FOREST HEIGHTS ESTATES GRADING & EROSION CONTROL PLANS

**FOREST HEIGHTS CIRCLE
GRADING & EROSION CONTROL PLAN**
TITLE SHEET

FOREST HEIGHTS CIRCLE GRADING & EROSION CONTROL PLAN
GENERAL NOTES AND EROSION CONTROL DETAILS

**FOREST HEIGHTS CIRCLE GRADING & EROSION CONTROL PLAN**  
GENERAL NOTES AND EROSION CONTROL DETAILS

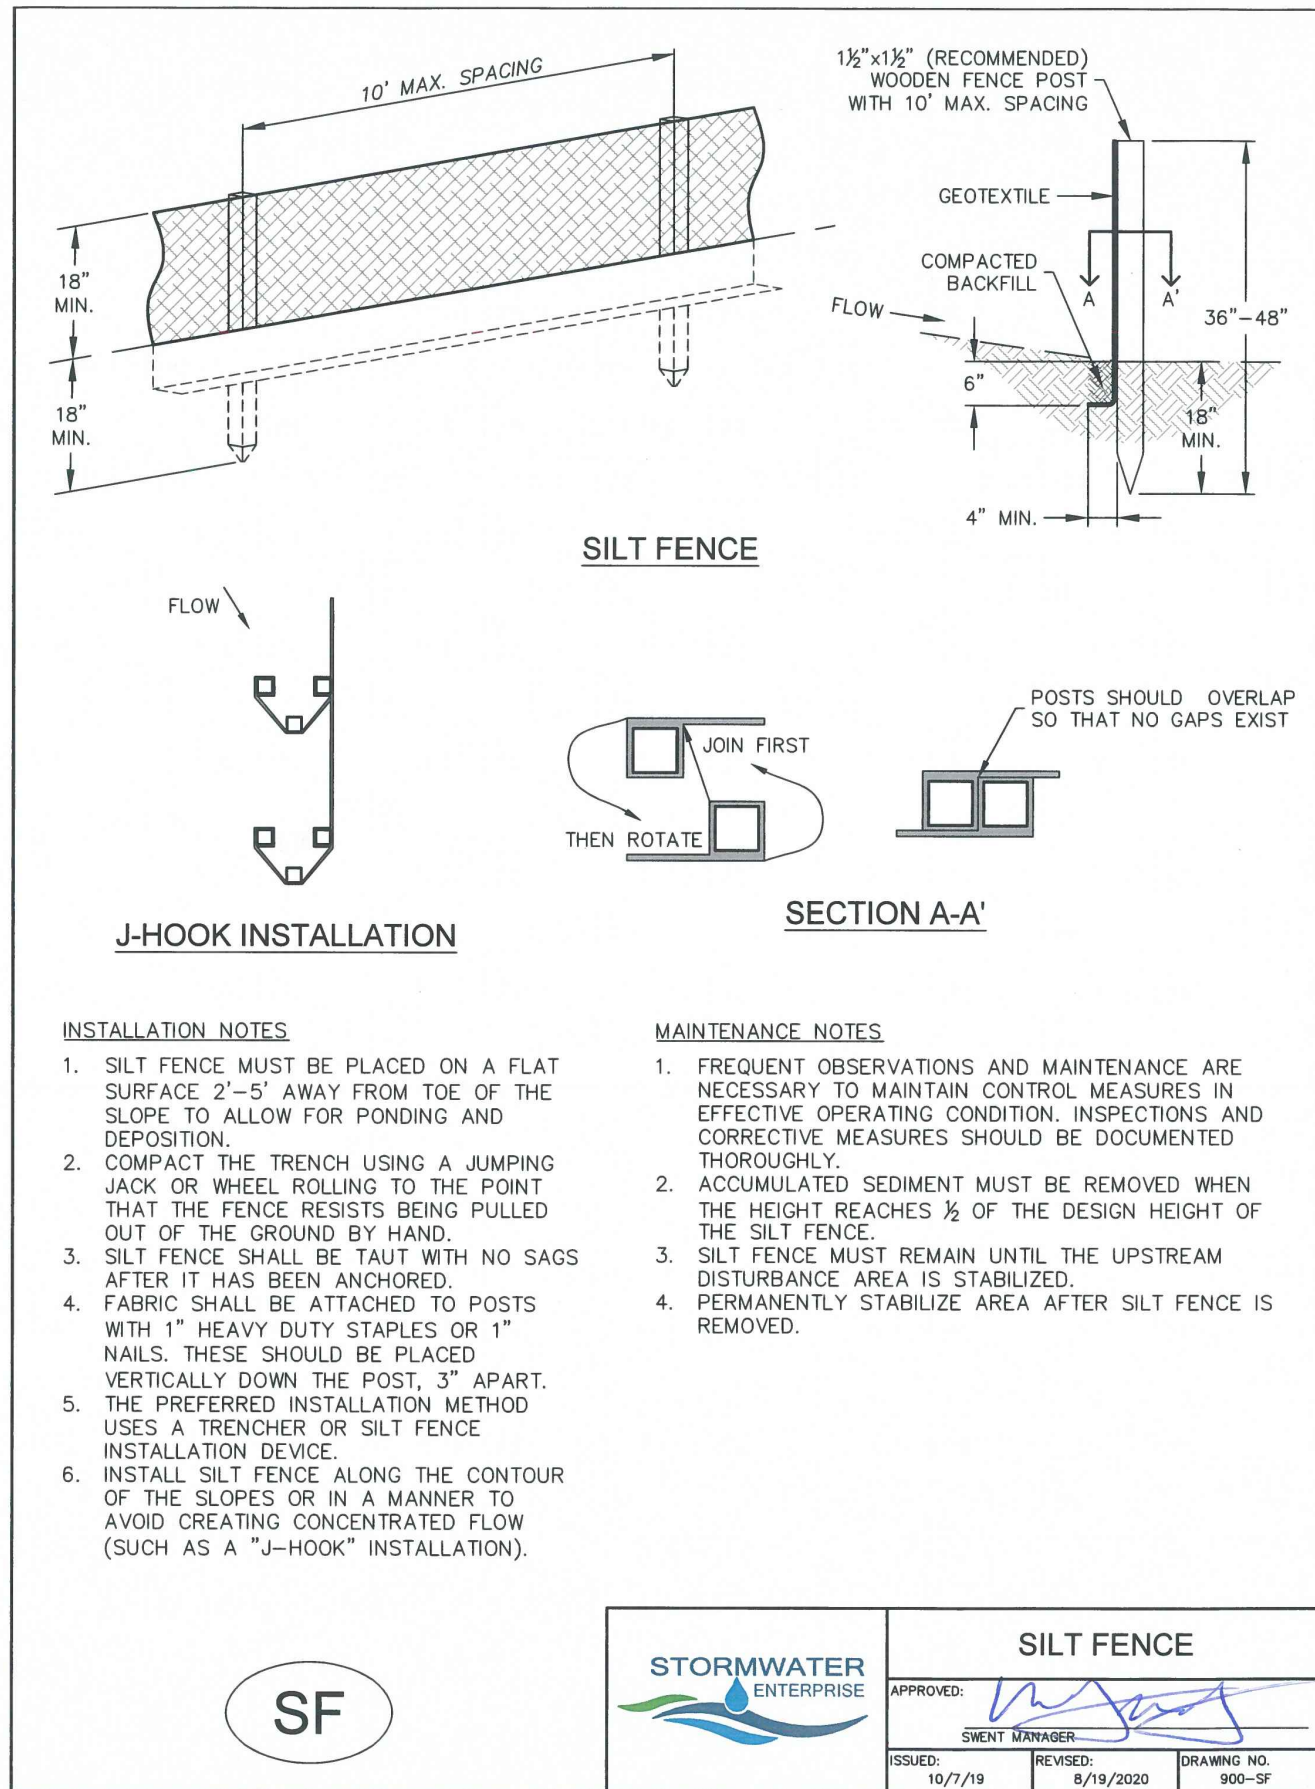
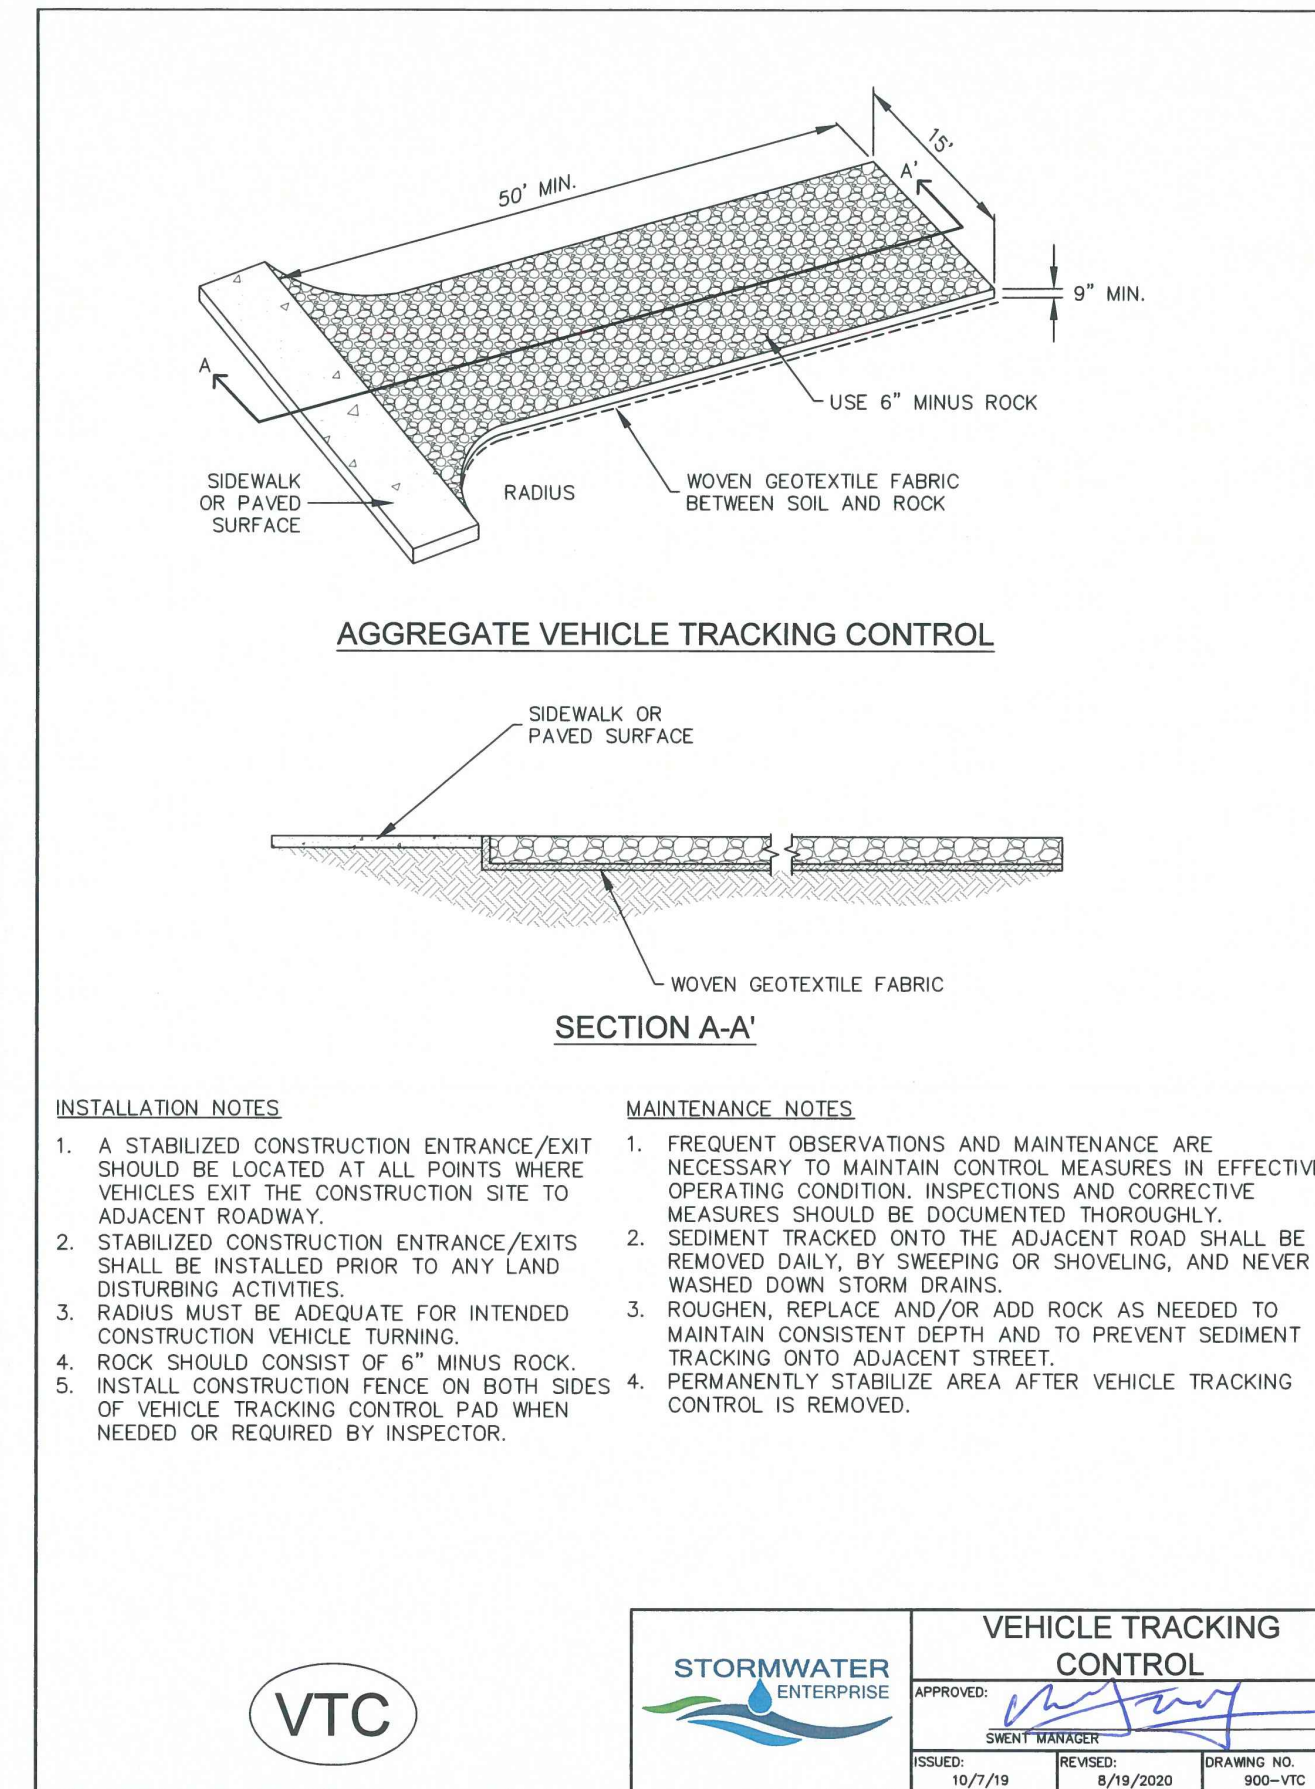
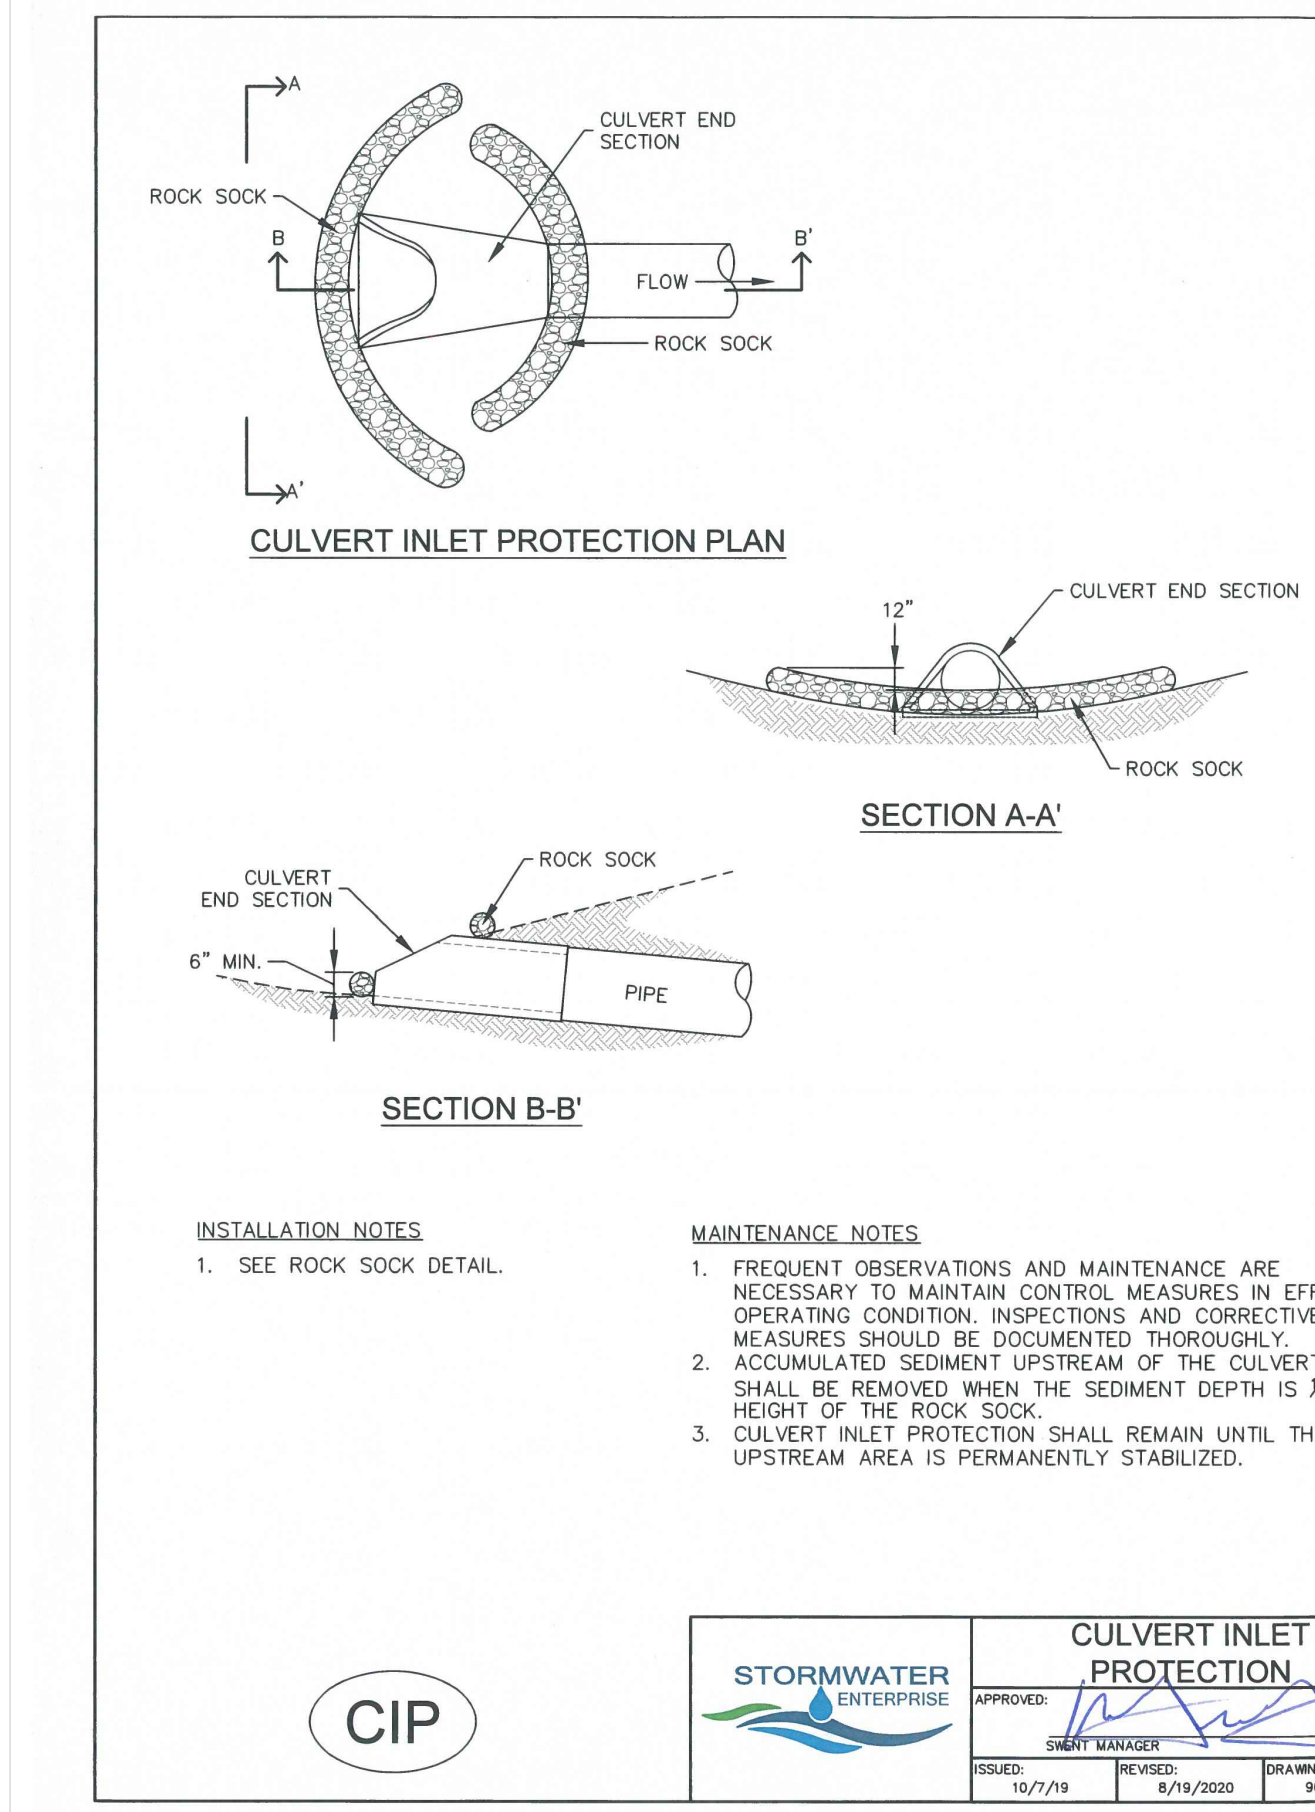
Comment generated due to changes in the document from previous submittal, per my comment on pdf pg 93 of the v3 FDR:
It is unclear how these grass species compare to those in DCMv1 Chap 10.7, Table 10-4. Please clarify with a note here or via a discussion in the FDR what velocity and slope is permissible with these species since these are not shown on Table 10-4.

With Review #2 and #3, I asked for the VTC detail to be revised/replaced to meet our EPC criteria. With this Submittal #4, the detail was removed completely. A detail is needed since a VTC is still shown on the GEC Plan below. So please add in an acceptable VTC detail with a min 75ft length. For reference, below is my Review #3 comment:

If a VTC is added to the plans above, add a VTC detail to this sheet. And make sure to use a EPC approved VTC detail (VT-1 and VT-2 in DCMv2, Chap 3.3) or revise other detail (which usually have 50ft length) to be 75ft min length.
